OXFORDSHIRE COUNTY COUNCIL'S RESPONSE TO CONSULTATION ON THE FOLLOWING DEVELOPMENT PROPOSAL

Application no: 15/01326/OUT-2

Proposal: OUTLINE - Up to 280 dwellings (including 30% affordable housing), introduction of structural planting and landscaping, formal and informal public open space and play areas, surface water flood mitigation and attenuation, new priority junction arrangements to White Post Road, creation of section of spine road to link Bloxham Road with White Post Road as well as creation of 34 space car park and other associated ancillary works. All matters reserved except for access

Transport

STUDY JUNCTIONS

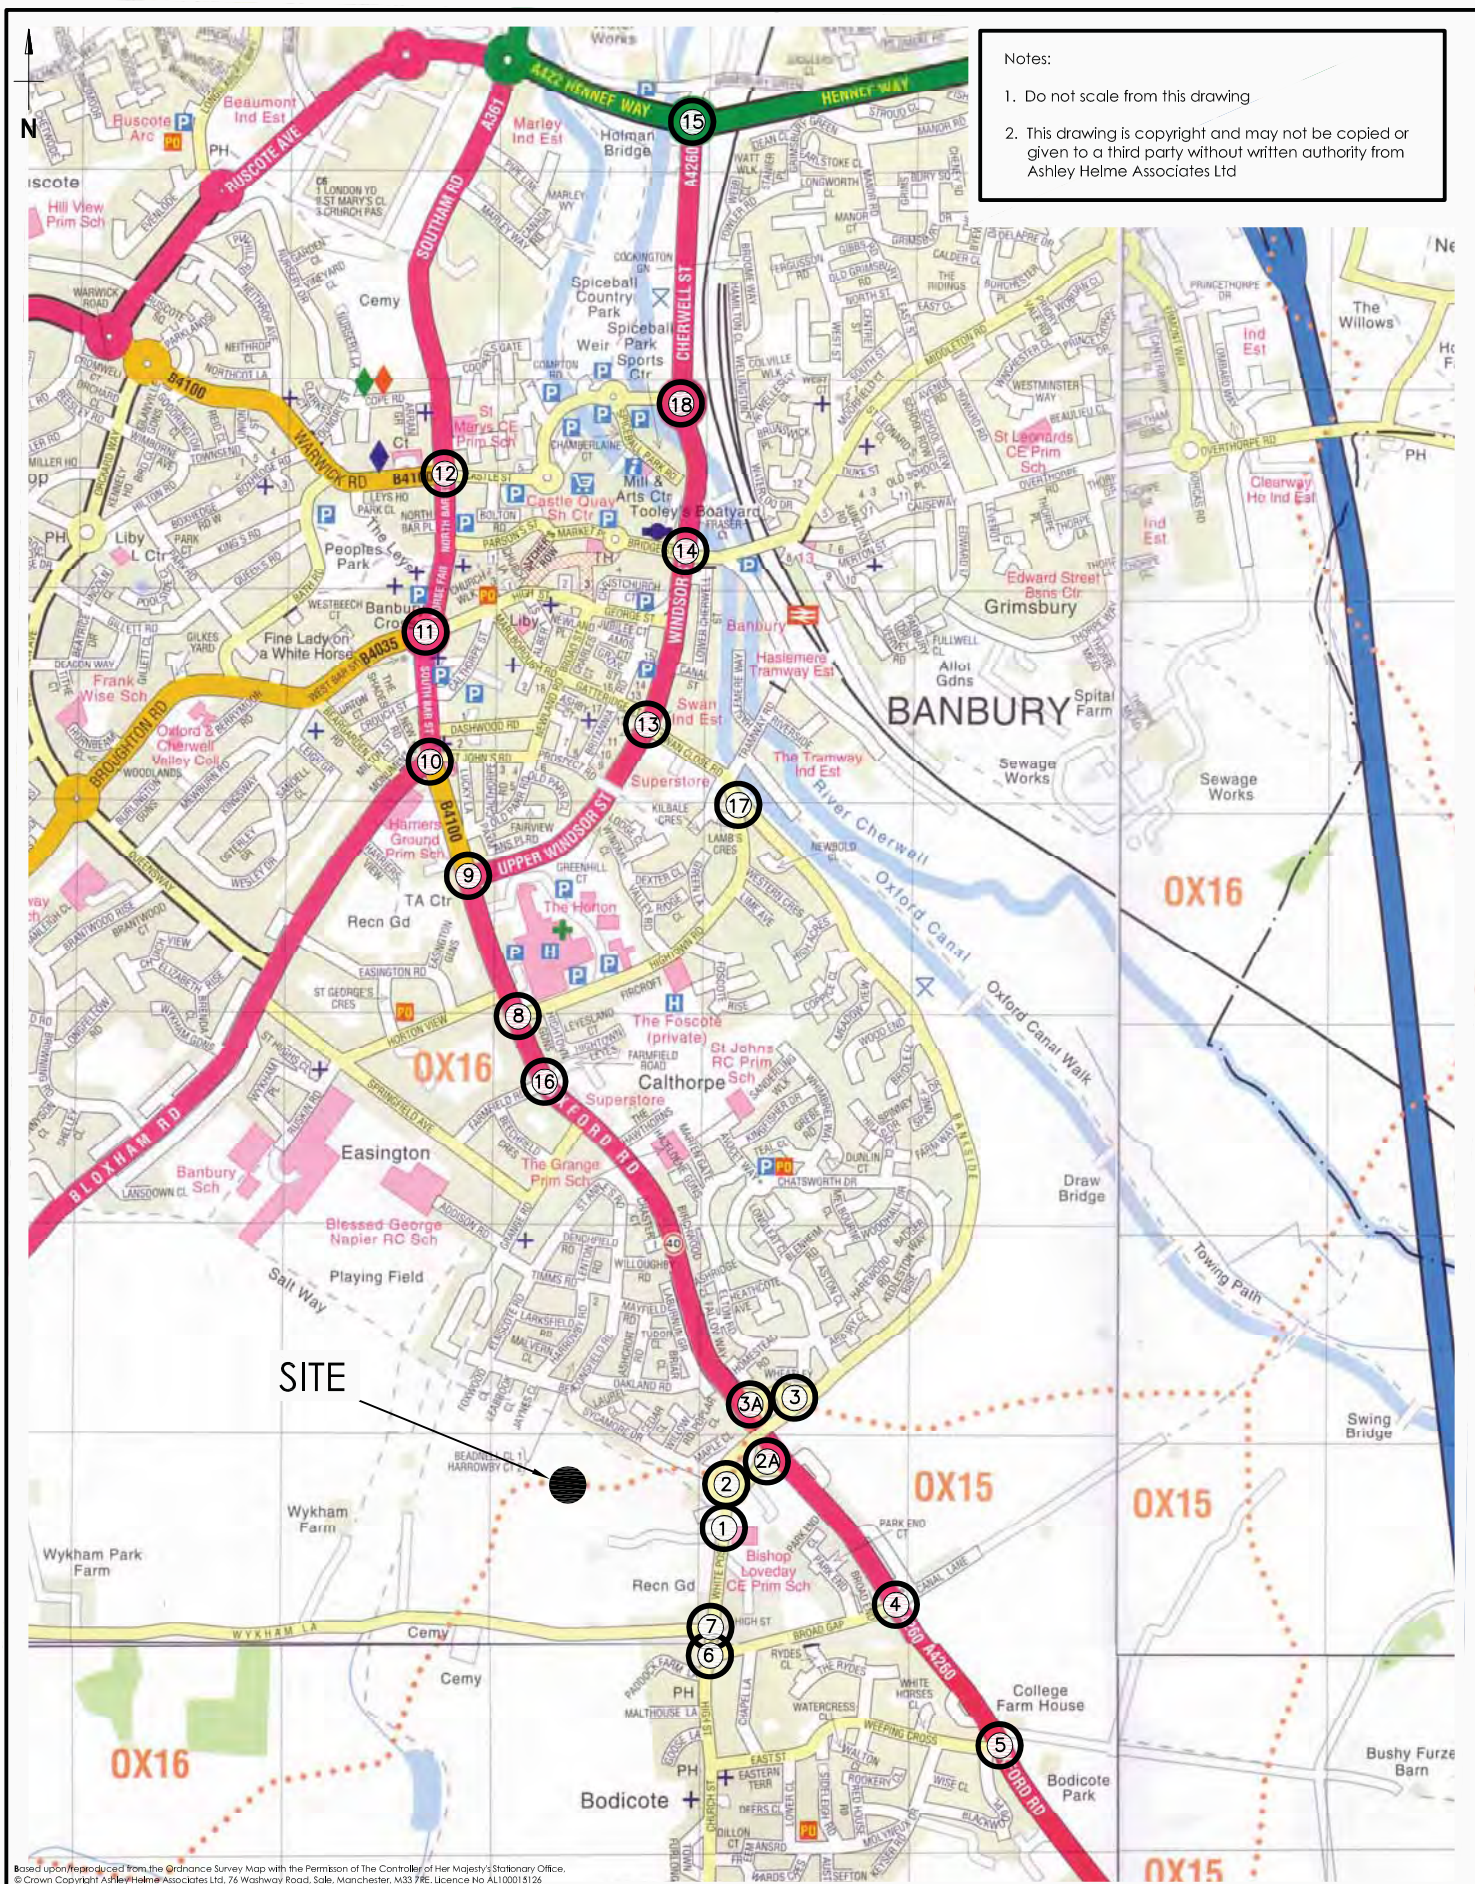
I disagree with the TA's assertion that the proposed development does not lead to a material traffic impact at Junction 16. Although the junction is at a high Degree of Saturation in the 2025 base scenario, the addition of the development traffic takes it close to 100% saturation (98.5%) and adds 12 vehicles (almost doubling) to the queue on Oxford Road north Left/Ahead.

WALK ISOCHRONES & LOCAL AMENITIES

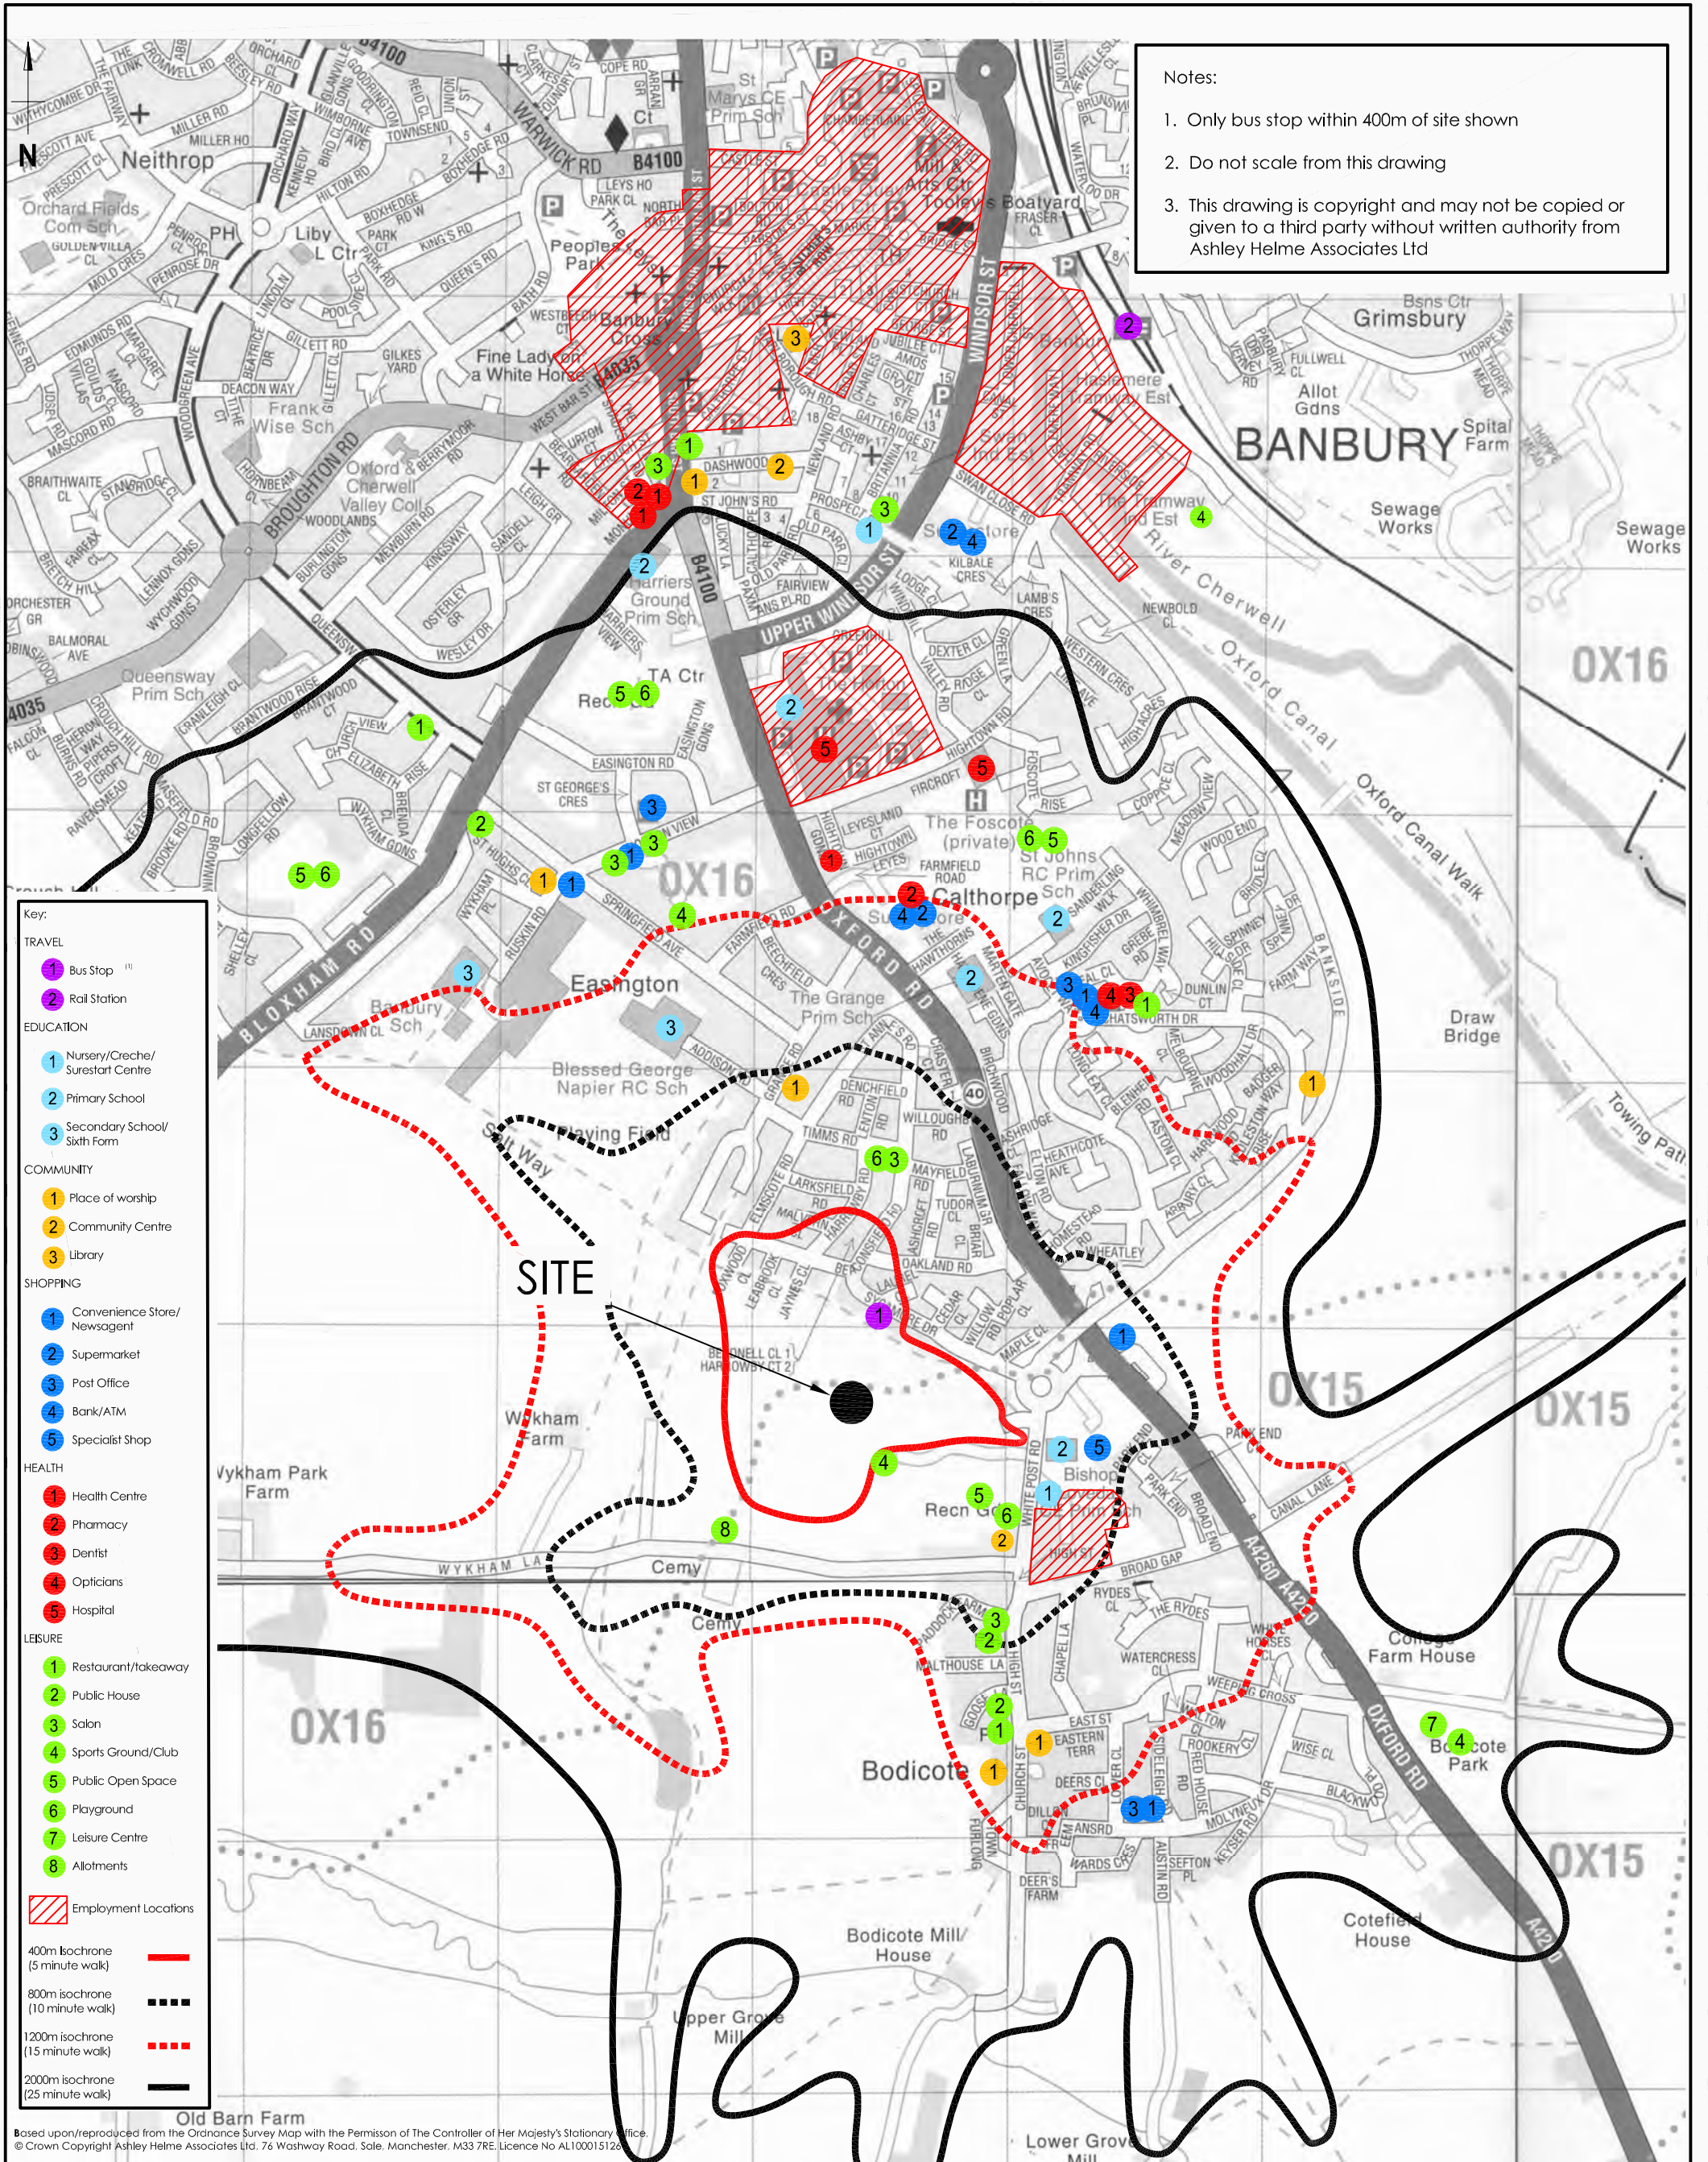
Pedestrian linkage across Salt Way must be secured in order for this development to be acceptable. I note that the links have been reduced to one, at the Public Right of Way. The walking isochrones in Figure 3 must assume that this connection is provided – without this connection walking distances would be significantly increased. However, clarification on the assumed connections should be provided since it is unclear how the revised isochrones have been produced.
